# CITY OF ALBUQUERQUE

**RE: Solare Charter School  
Conceptual Grading and Drainage Plan  
Engineer's Stamp Date: 05/24/19  
Hydrology File: M09D031**

Based upon the information provided in your submittal received 05/24/2019, the Conceptual Grading Plan **is not** approved for action by the DRB for Preliminary Plat. The following comments need to be addressed for approval of the above referenced project:

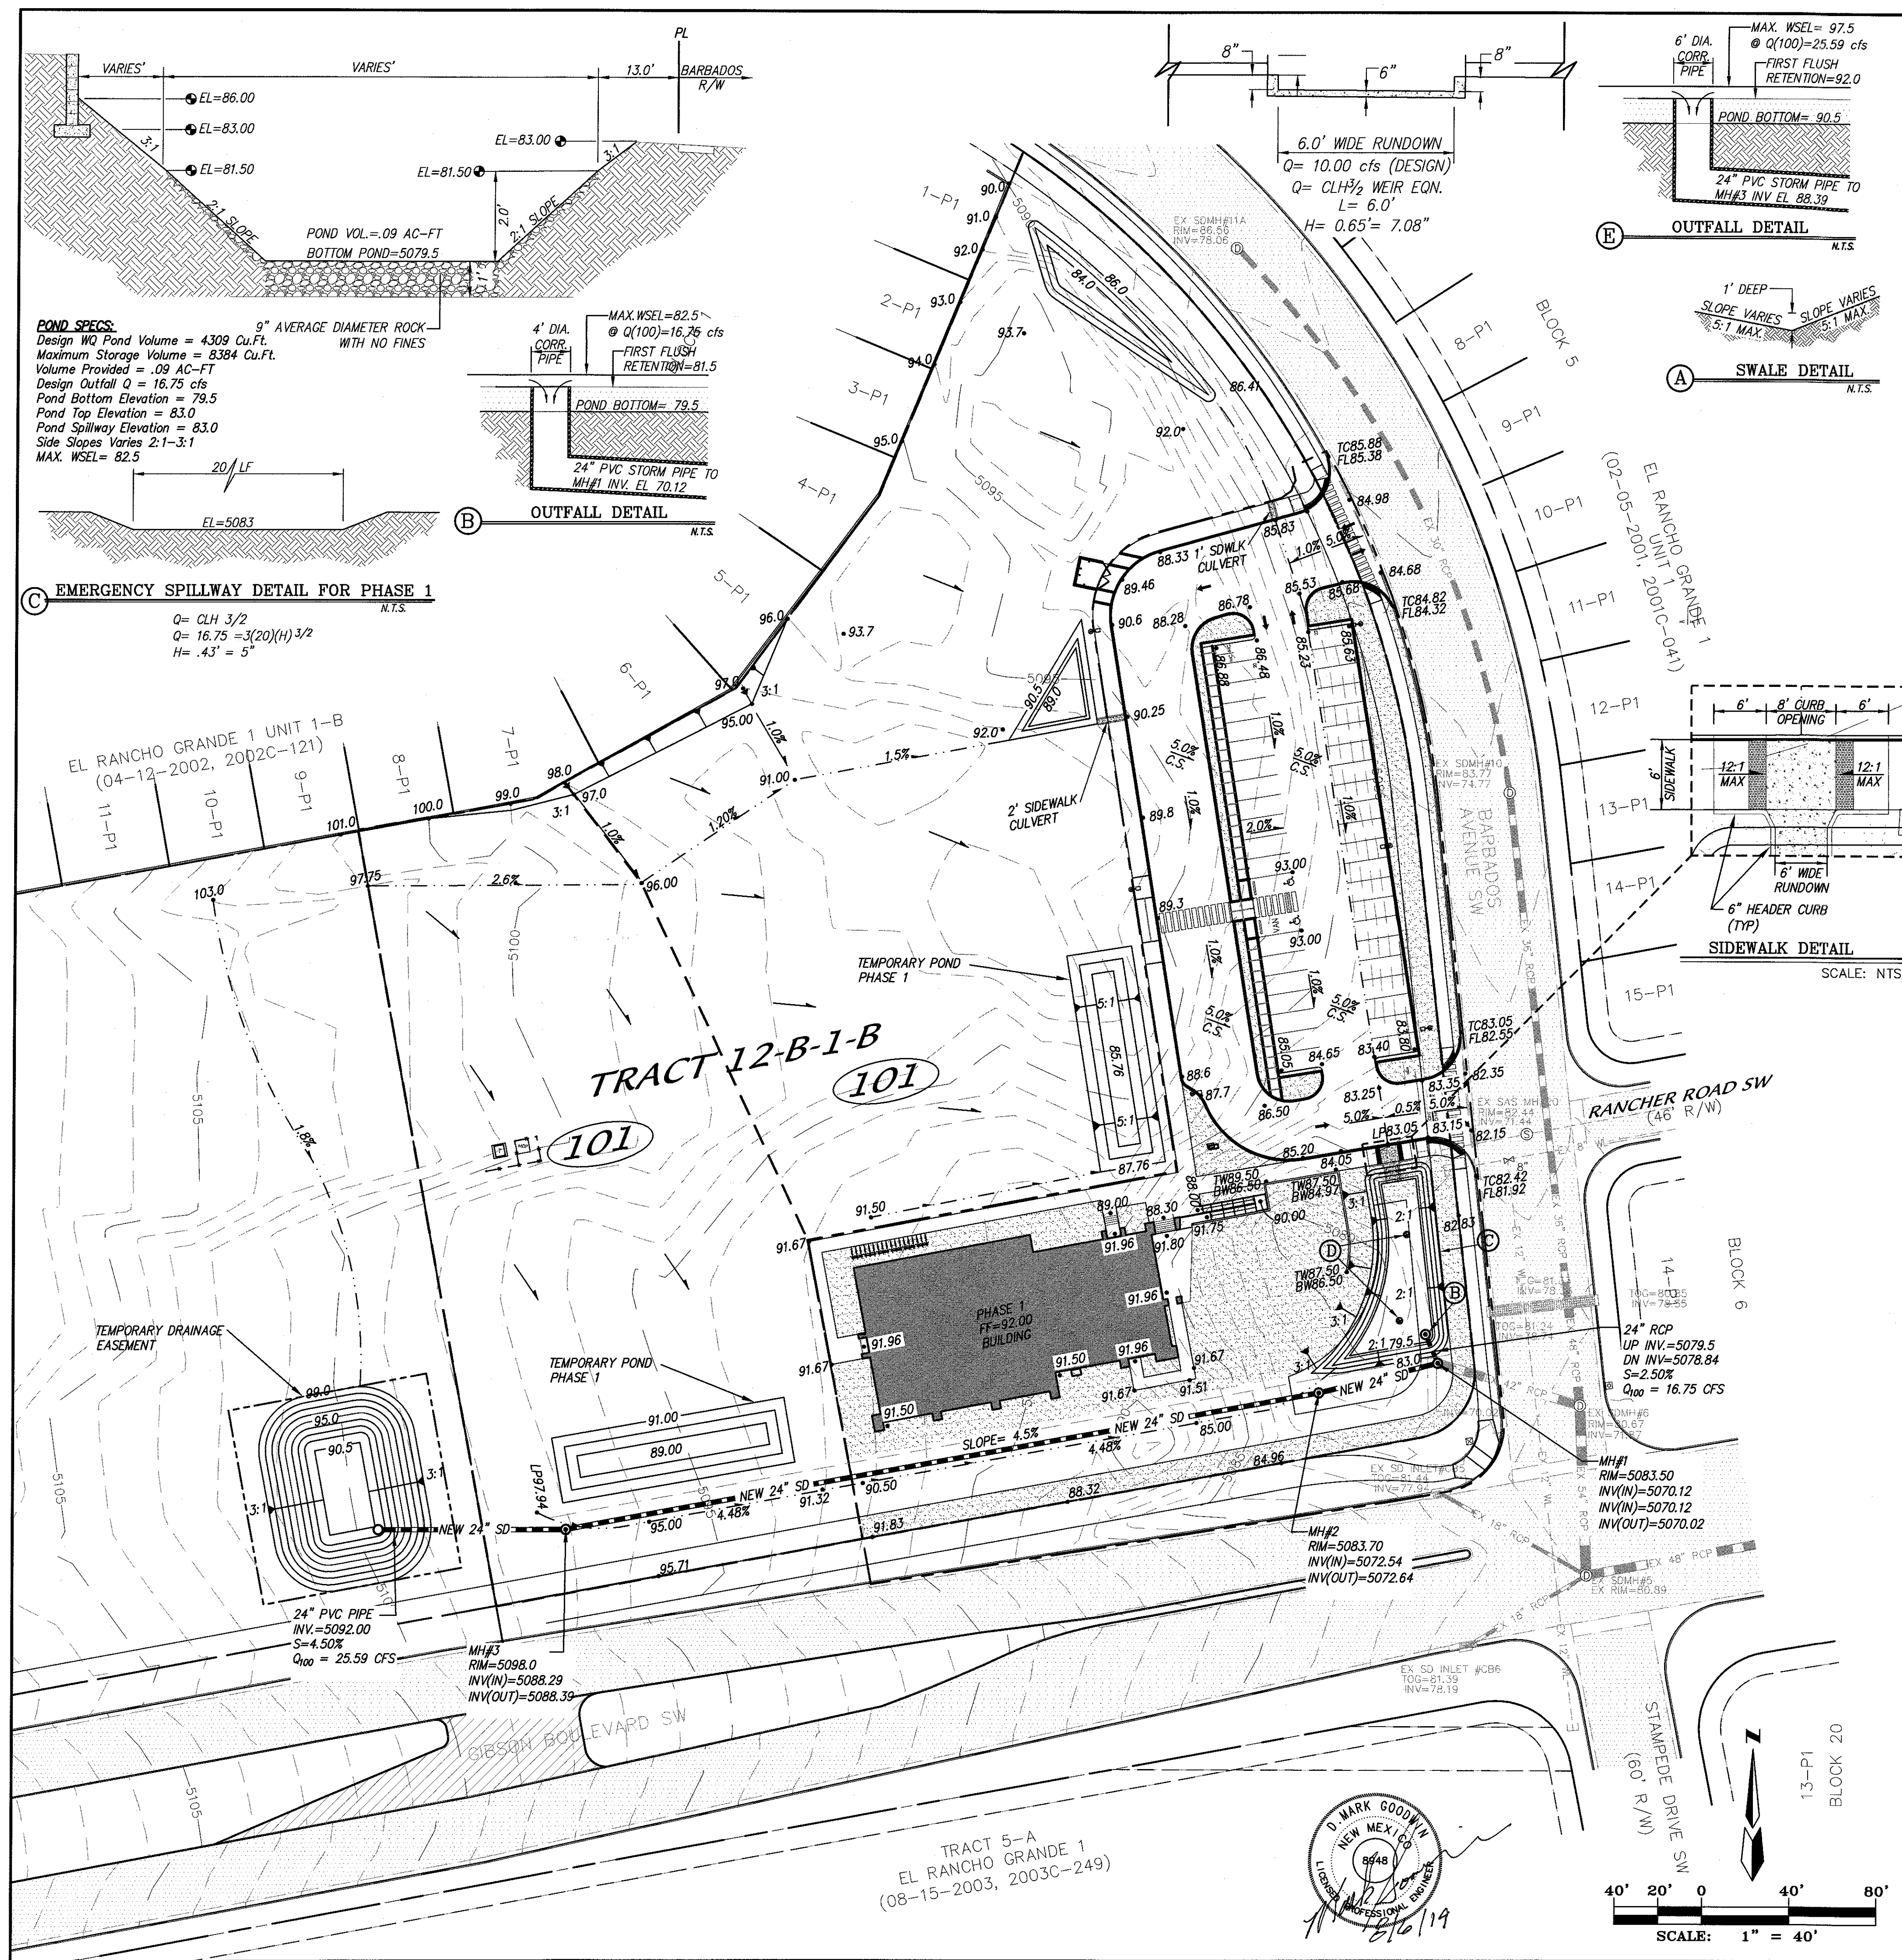
1. Please add the word "Conceptual" to the sheets title and add a note stating "Not for Construction".

2. Please add the drainage calculations from newly adjacent tract. Since you do not know what is going to be built, just assume the worst case a commercial site with 90% impervious cover.

3. Please include the whole site (both proposed tracts) and not just the school site. How is the drainage from newly adjacent tract being handled? Does a storm pipe need to extend from the onsite existing 42" pipe through a drainage easement? Can the drainage from the newly adjacent tract be handled within Gibson's road capacity? Can the drainage from the newly adjacent tract be captured with the existing inlet on Gibson or does another inlet need to be installed?

4. Please show all existing storm sewer pipes within the R.O.W. on both Gibson & Barbados. This can be taken from the as-built drawings.

5. Please add emergency spillways for the two stormwater quality ponds at the northeast area of the school site. This can be handled with sidewalk culverts.
